A14 CAMBRIDGE TO HUNTINGDON IMPROVEMENT SCHEME
DEVELOPMENT CONSENT ORDER

WRITTEN REPRESENTATION BY
HUNTINGDONSHIRE DISTRICT COUNCIL

A14 Cambridge to Huntingdon Improvement Scheme
Alconbury to Brampton NMU Proposals -
A14/A1 south of Brampton Hut
 Sheet 3 of 3

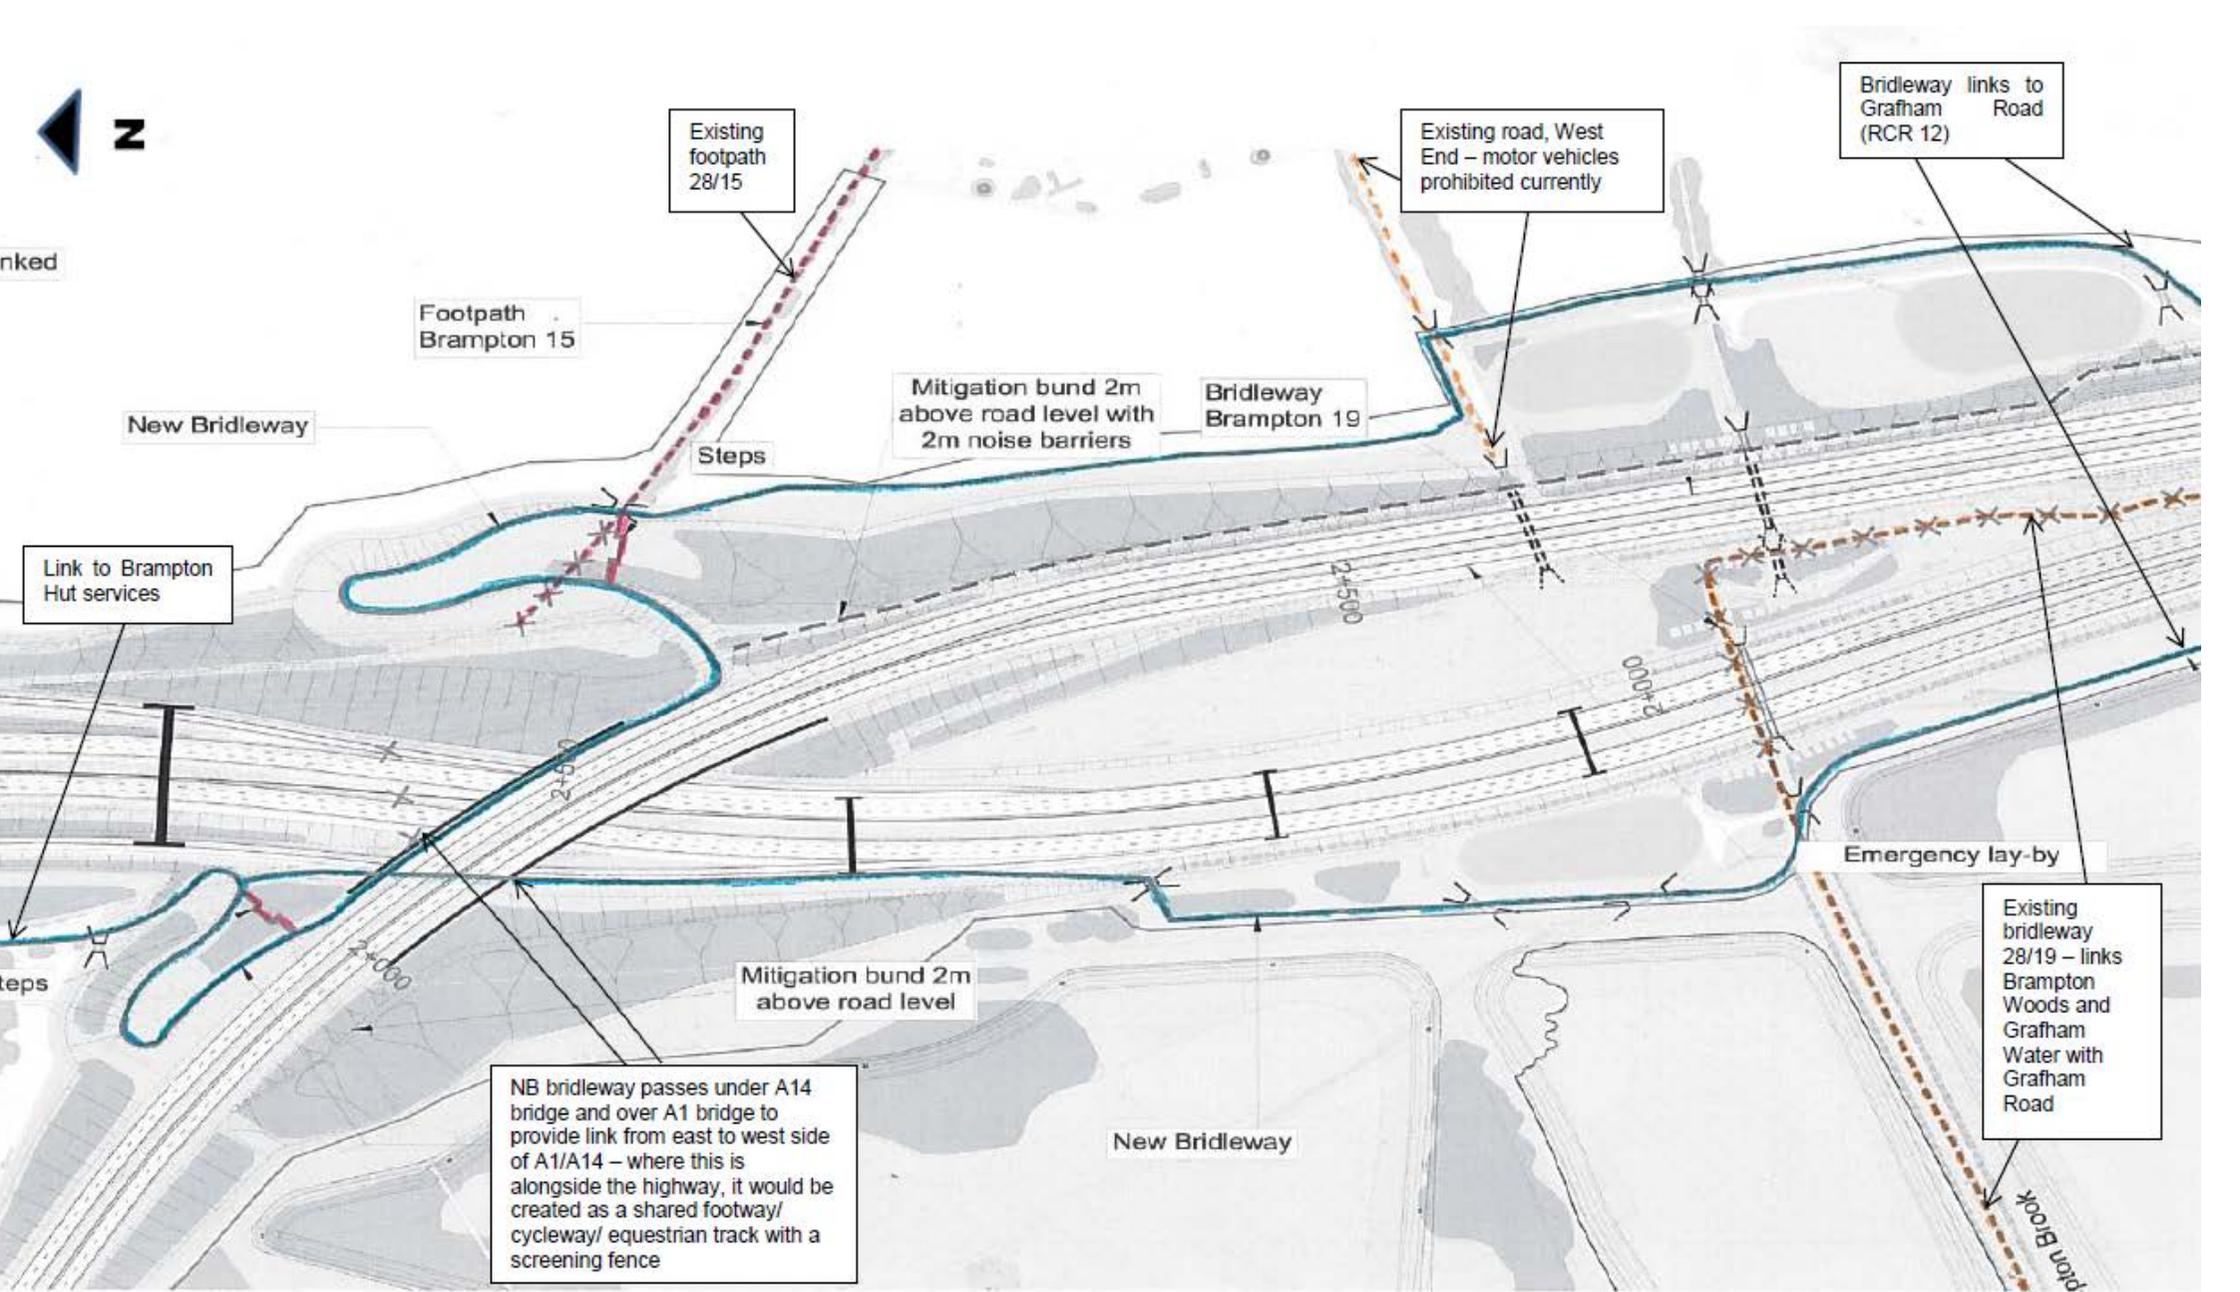
- ii) As part of the discussions relating to the re-creation of routes between Brampton village and Brampton Woods, a proposed route alignment has been agreed in principle with the Applicant, via ramp features and steps and crossing the A1 via the proposed A14 over-bridge

- iii) The Council is concerned that the proposed route via the over-bridge is located very close to A14 eastbound traffic flow. While the Applicant has stated that the bridleway on the bridge will be of sufficient width to conform with appropriate standards and separation of sufficient height to screen horse riders from traffic, the Council does not currently consider that this gives adequate reassurance that this link will be of suitable design

- iv) As well as the route passing close to A14 traffic flow, at the same time the route is also crossing the A1 with its projected traffic flows. The Council is of the view that the cumulative effects of the totality of the traffic flow could result in the use of the bridleway being unattractive to horse riders and that there is a need for more careful and sympathetic design required to meet the specific needs of users of this route

- v) The re-creation of this route is a vital element of achieving community integration and legacy on this part of the proposed route and the Council considers that this element requires a greater degree of certainty of design at this stage as alternative opportunities would not be possible at a future date if the indicative route currently indicated fails to meet the needs of projected users
